RE: 39 Hawthorne

CBL: 427-B-022

An evaluation of your building permit application fails to comply with the following sections of the 2003 International Residential Building Code of the of the City of Portland:

39 HAWTHORNE ST.  
PORTLAND, ME.

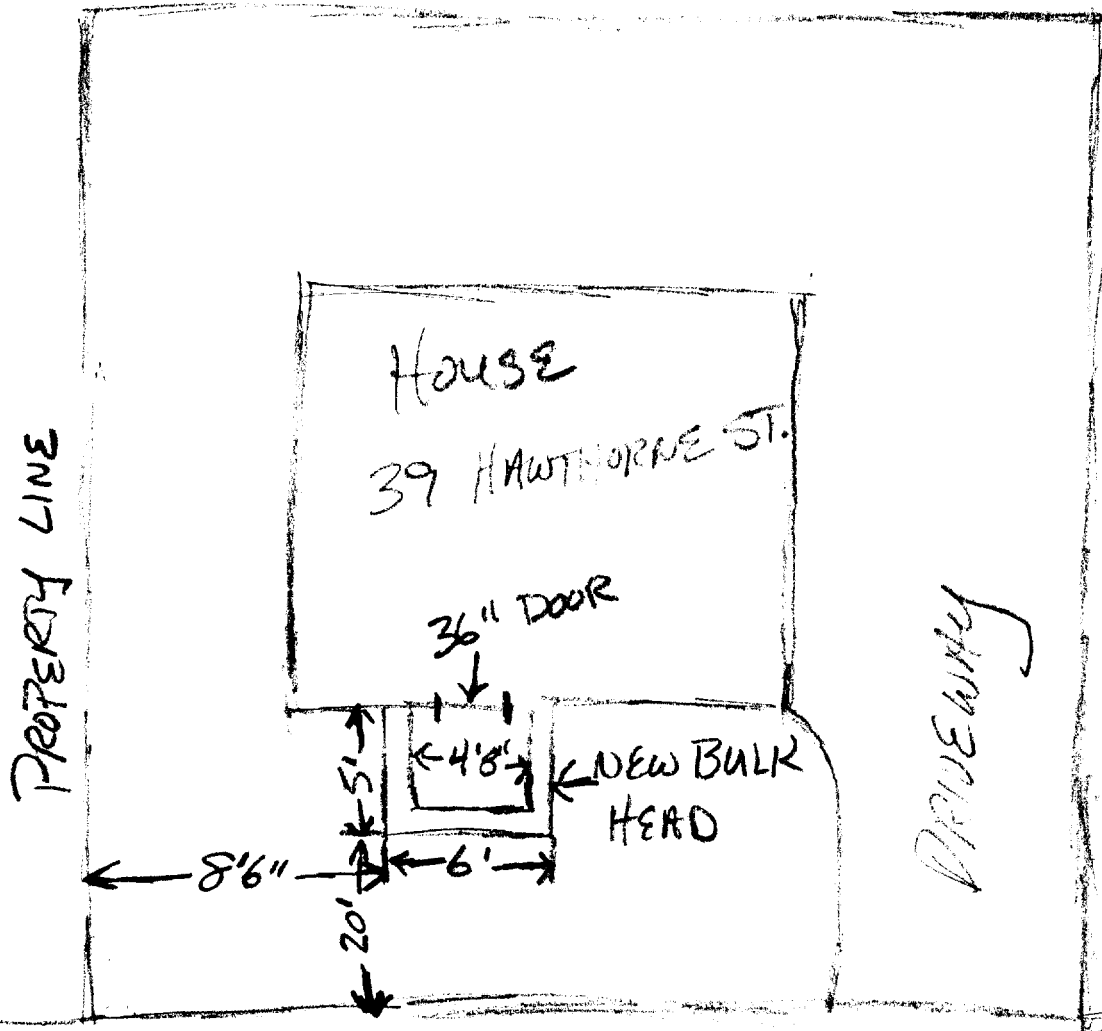
R106.2 Site Plan: The site plan originally submitted shows the structure located on the exact required setbacks, places the property at the maximum allowable lot coverage, and does not show complete footprints of structures with dimensions. As discussed with the property owner, a complete boundary survey of the property by a licensed surveyor must be completed due to the proximity of the setbacks and the lot coverage issue.

The above referenced permit application is denied pursuant to Section 105.3.1 An application with code compliant plans and a boundary survey of the property must be submitted with a new application in order to proceed with this project. Any construction activities started at this property will result in this office referring the matter to the City of Portland Corporation Counsel for legal action and possible civil penalties, as provided for in Section 1-15 of the Code.
